PRE-APPLICATION ADVICE NOTE

Reference : 22/02346/PAYPRE

Address: Ampney Park, Ampney Crucis, Cirencester

Date: 2/12/2022

05 Stables Cottage
RR200 West Elevation

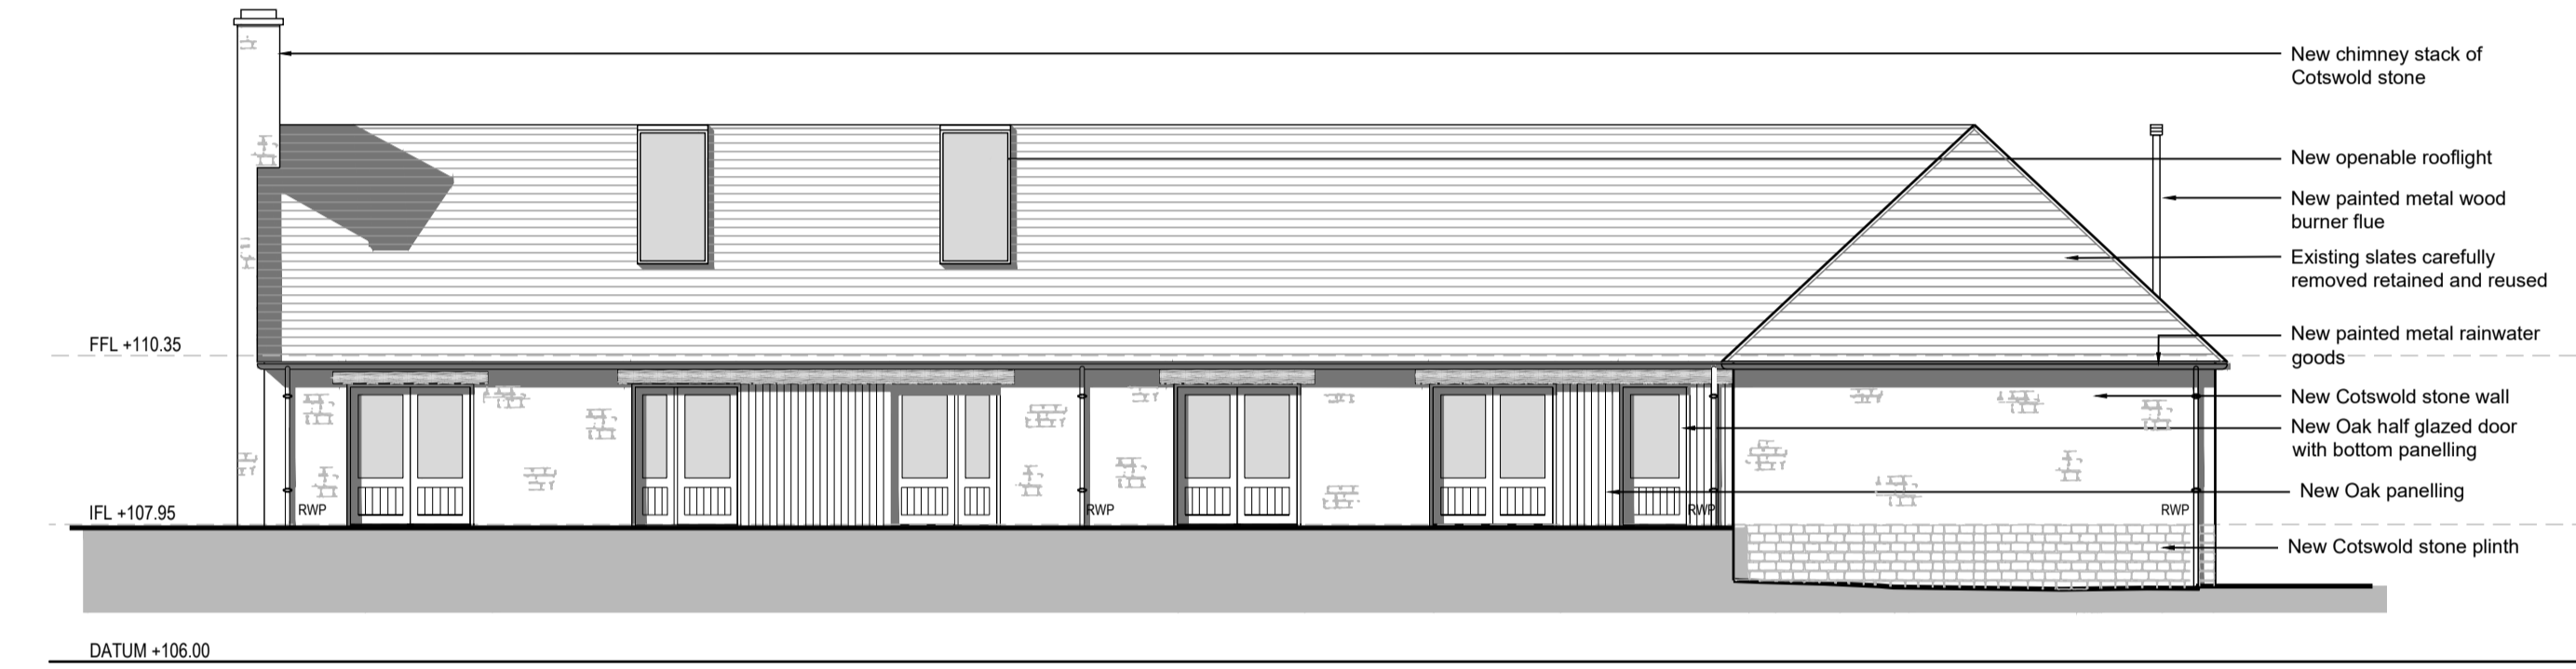
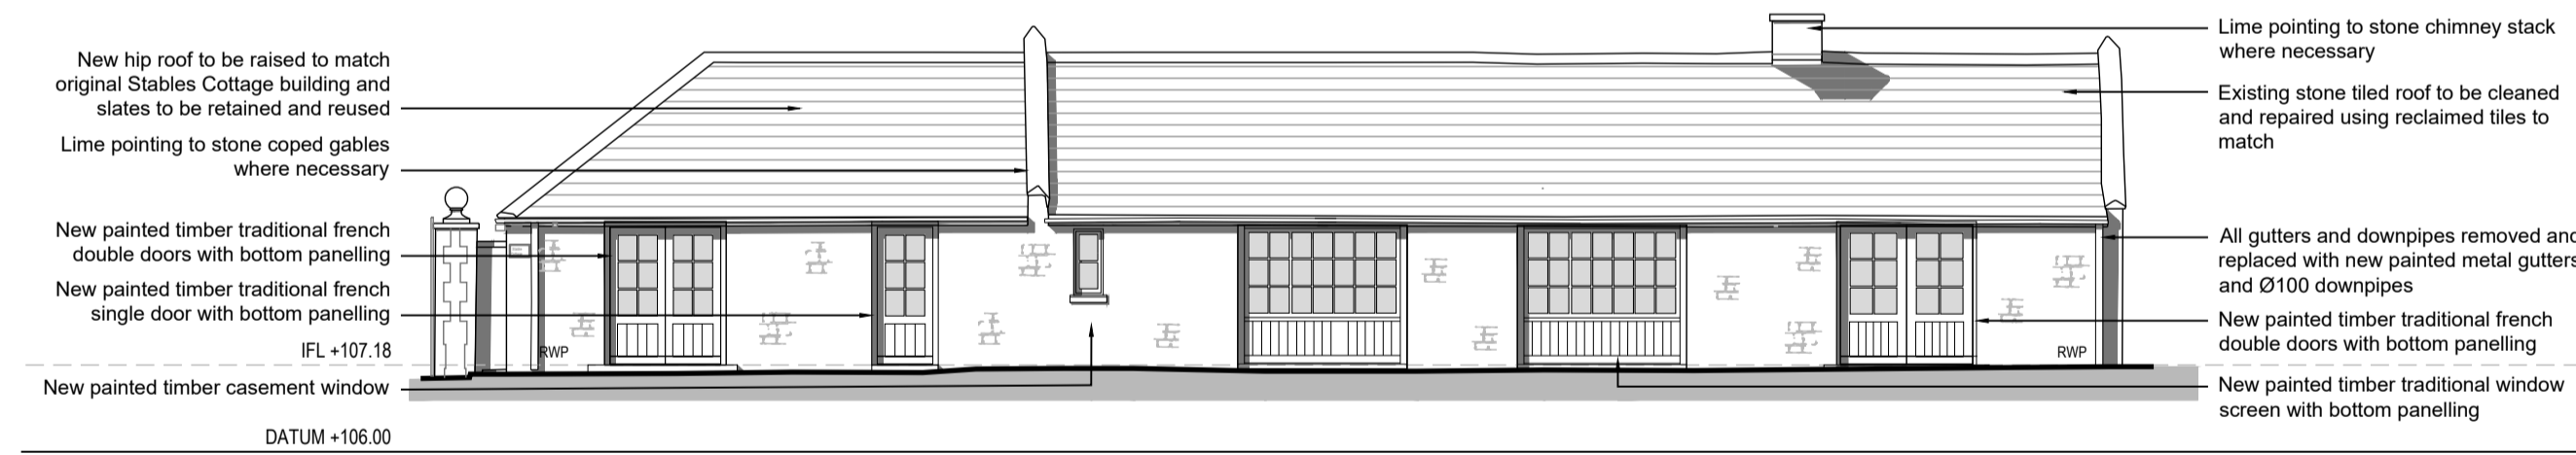
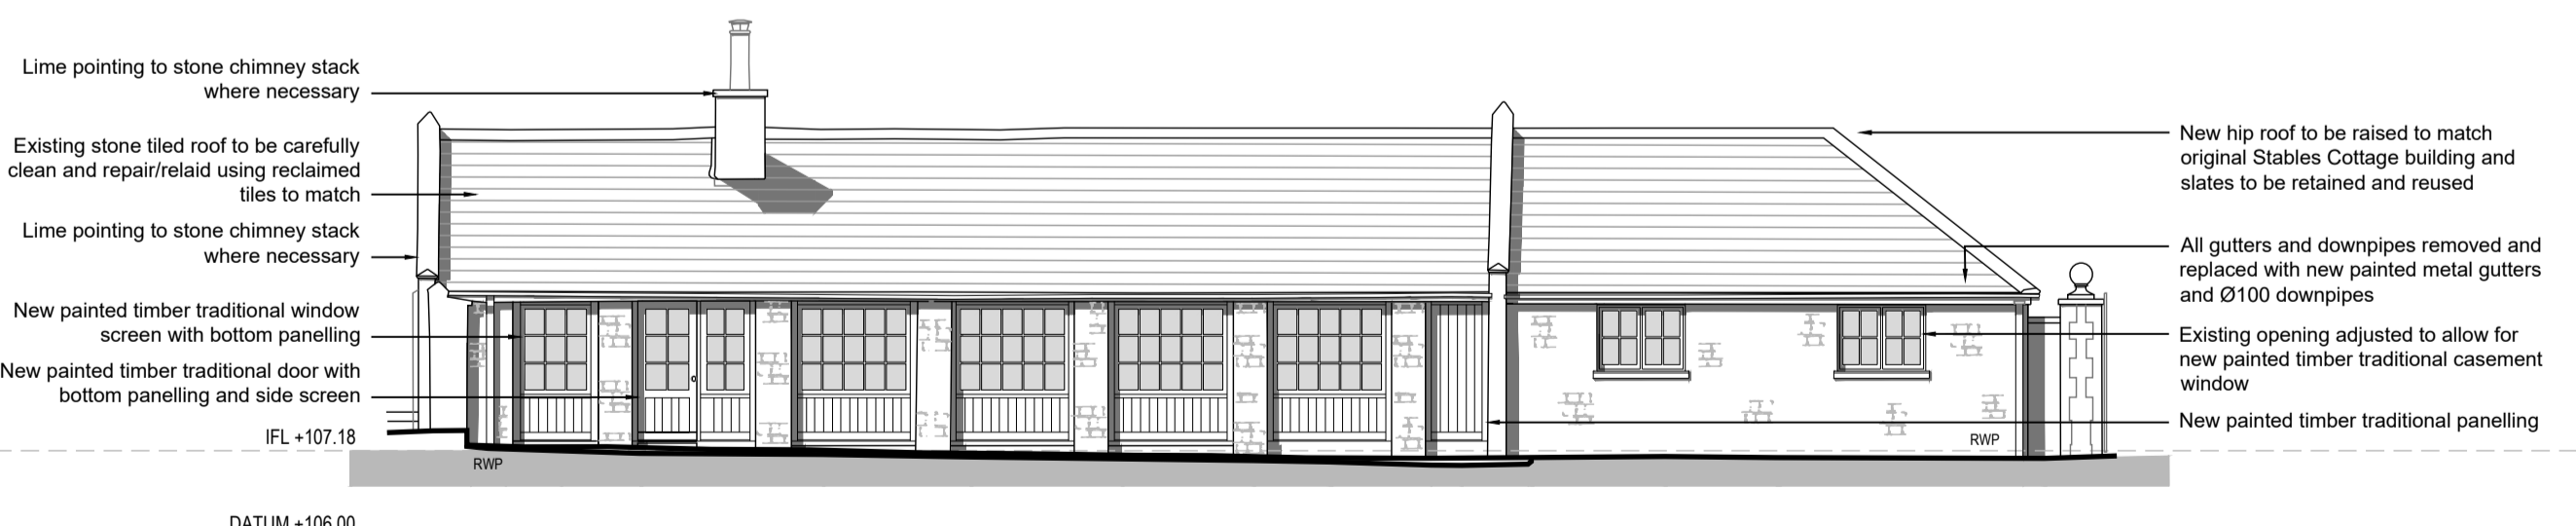
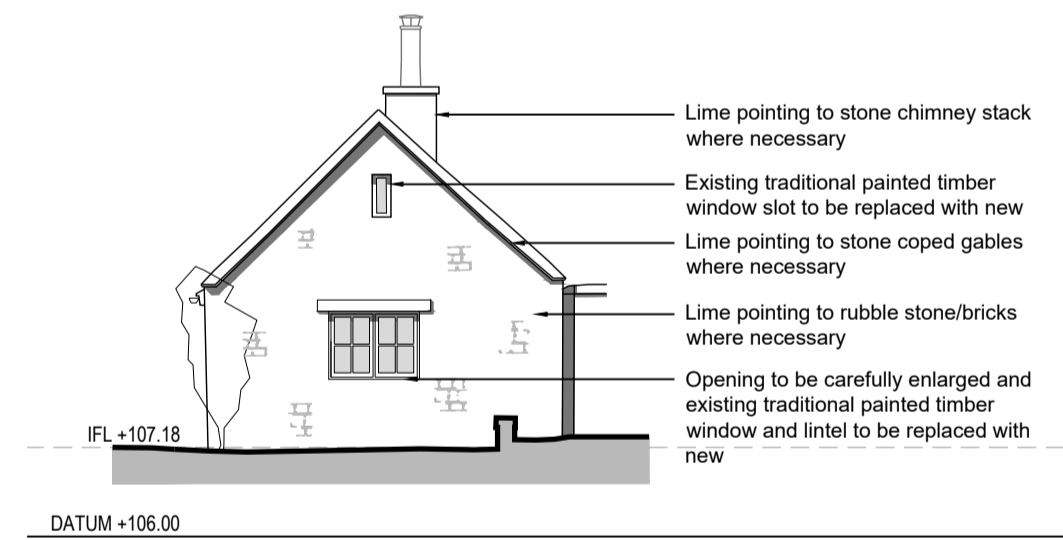
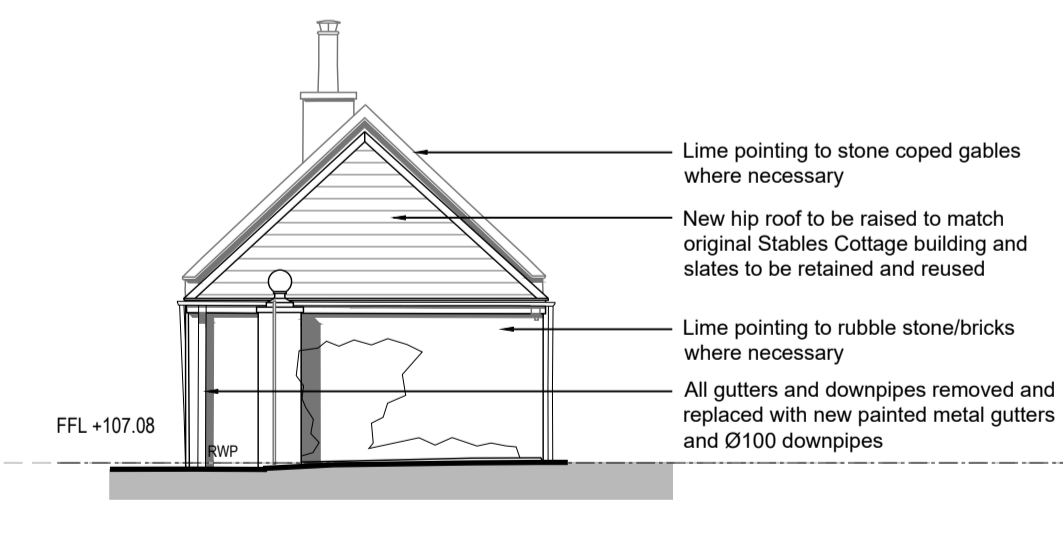
Generally, the internal alterations proposed to this building are likely to be acceptable. However there is an area in the centre of the ground floor area where the new kitchen is being created where some walling and partitions are proposed to be removed. We will need further information in terms of the latter to properly assess the impact of the proposed works on this part of the building.
